Thanet Extension Offshore Wind Farm

Annex A to Appendix 13 to Deadline 2
Submission: Log of Changes to the Draft
Development Consent Order

Revision B

Onshore Street Work Plans - Sheet 1 of 2

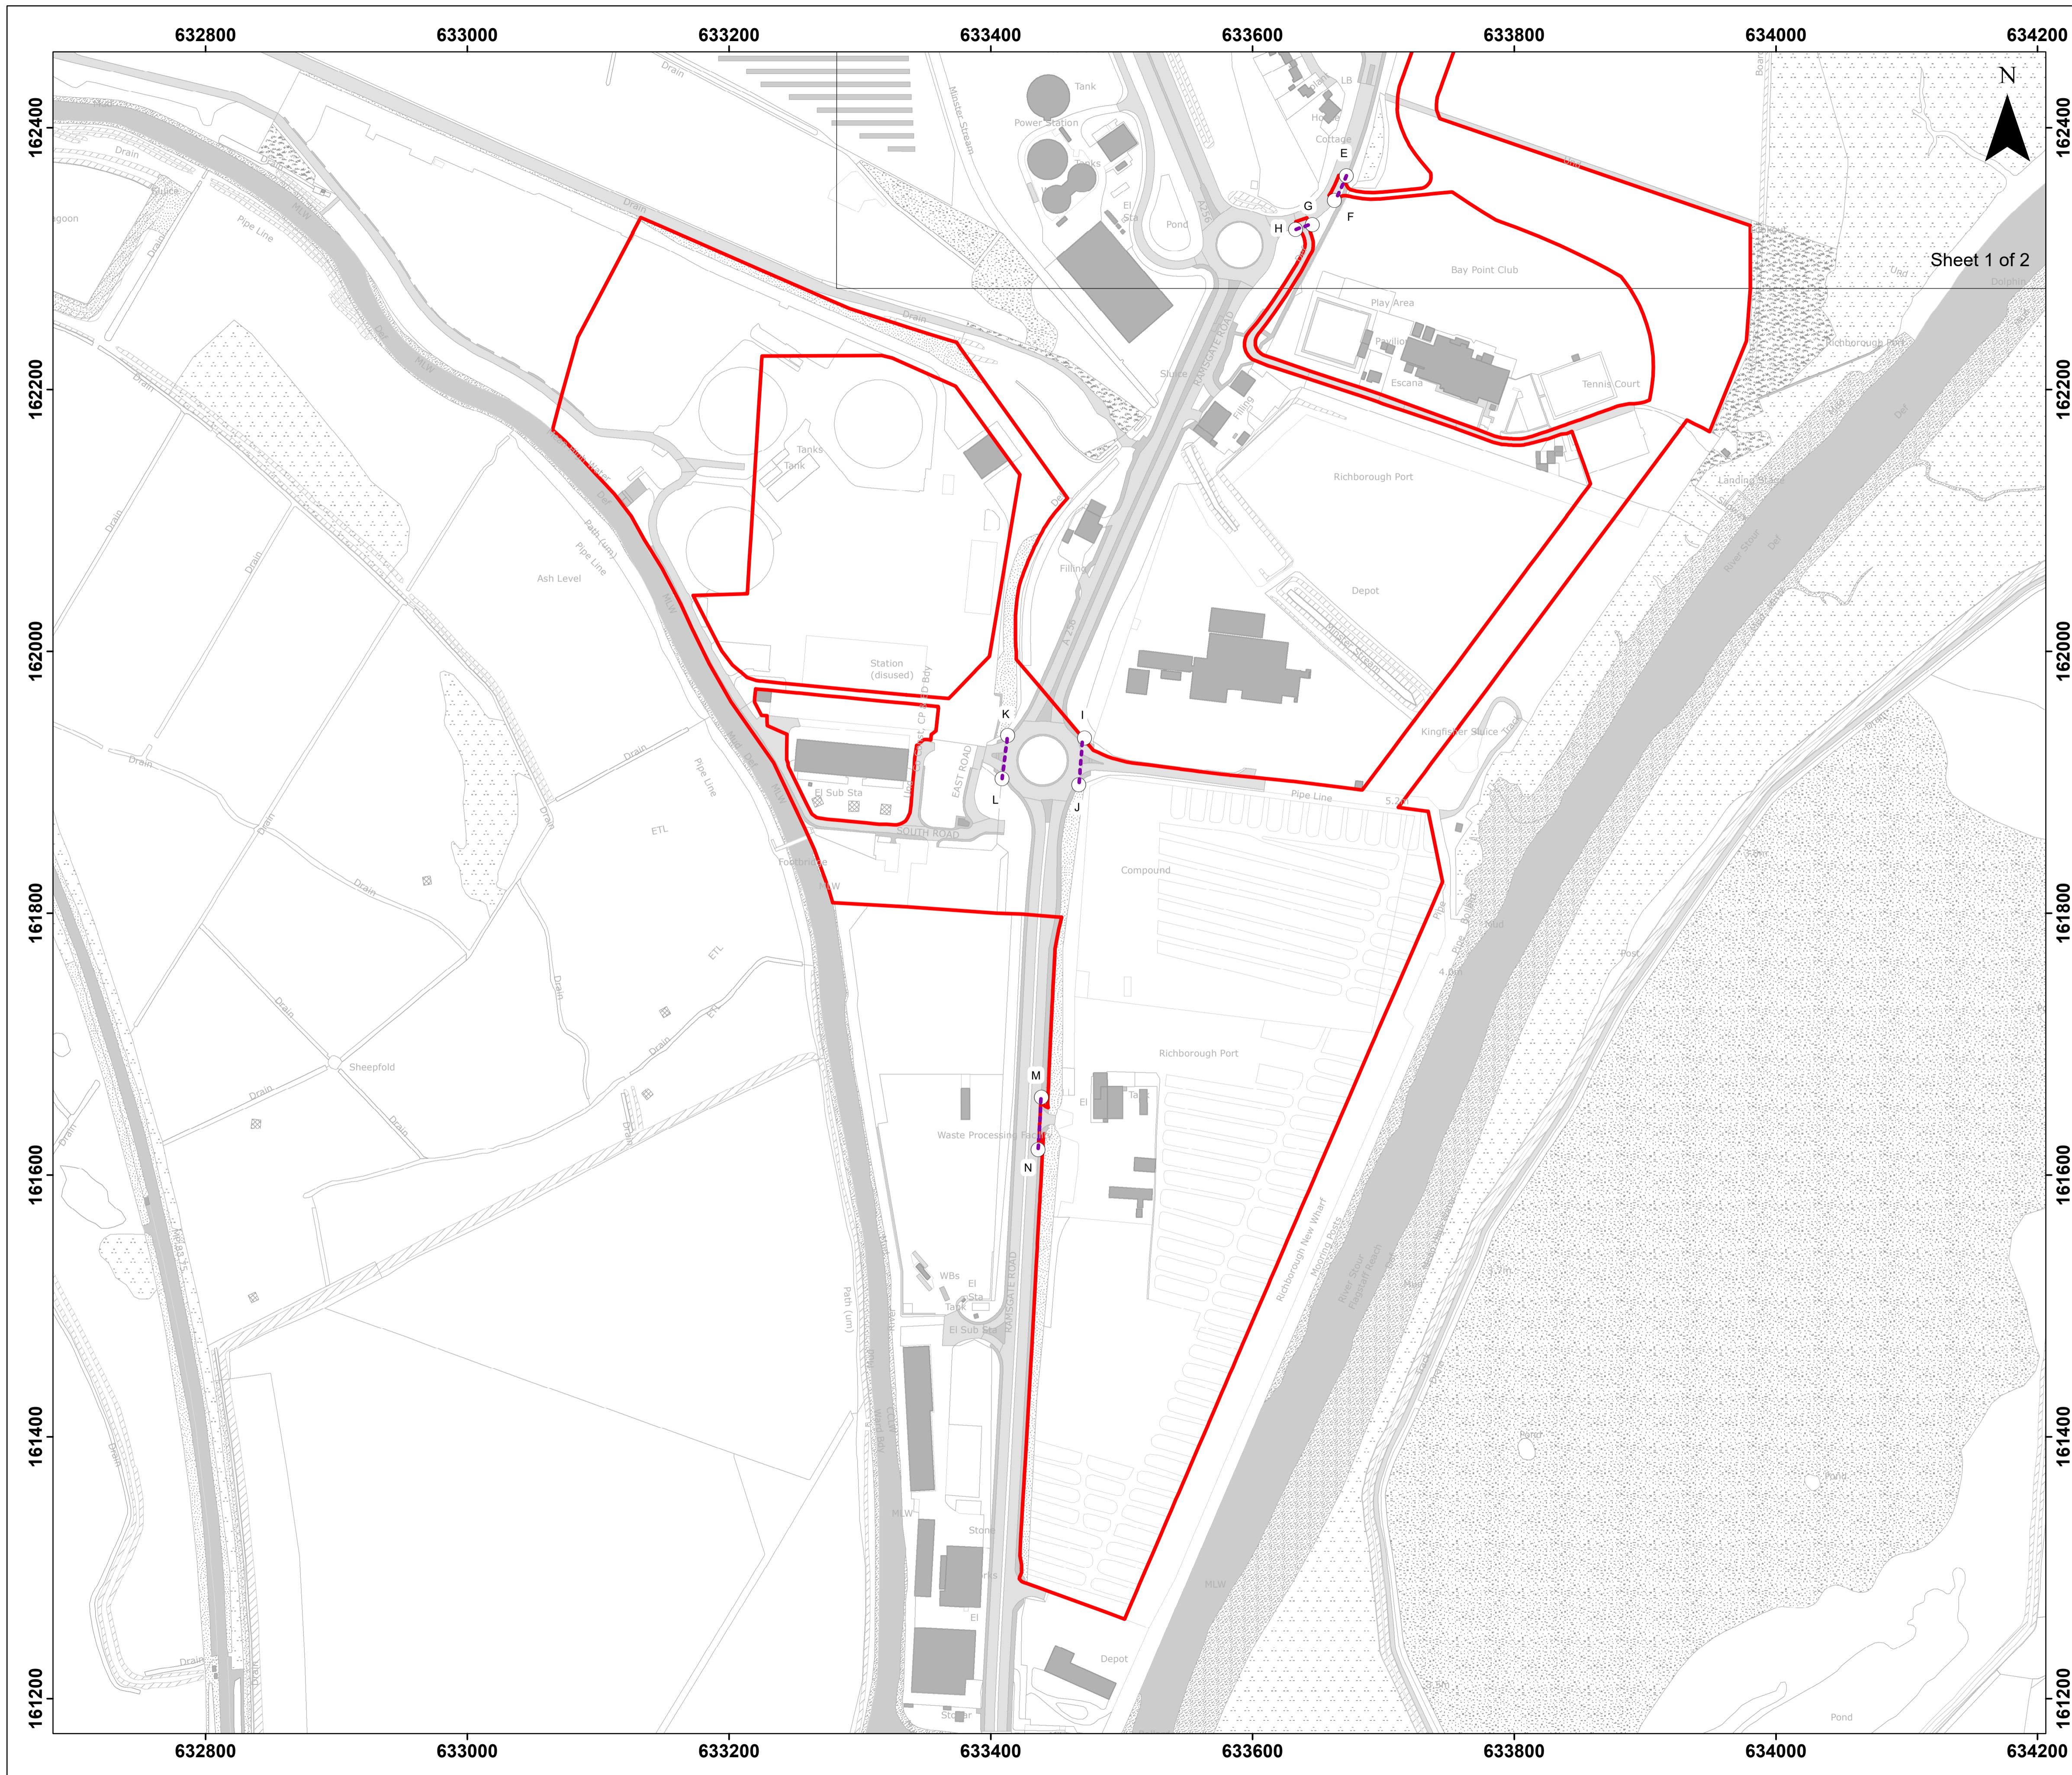
Ref	DCO Ref.	Rationale for change	Change made	DCO Version
1.	Schedule 2	In their Section 51 advice issued to the Applicant, the Planning Inspectorate noted that: “In relation to the dDCO Schedule 2, the dDCO refers to the works plans. This should be the onshore street works plans.”	The wording has been amended throughout Schedule 2, for example – <i>SANDWICH ROAD at reference point A-B on the <u>onshore street</u> works plan</i>	2
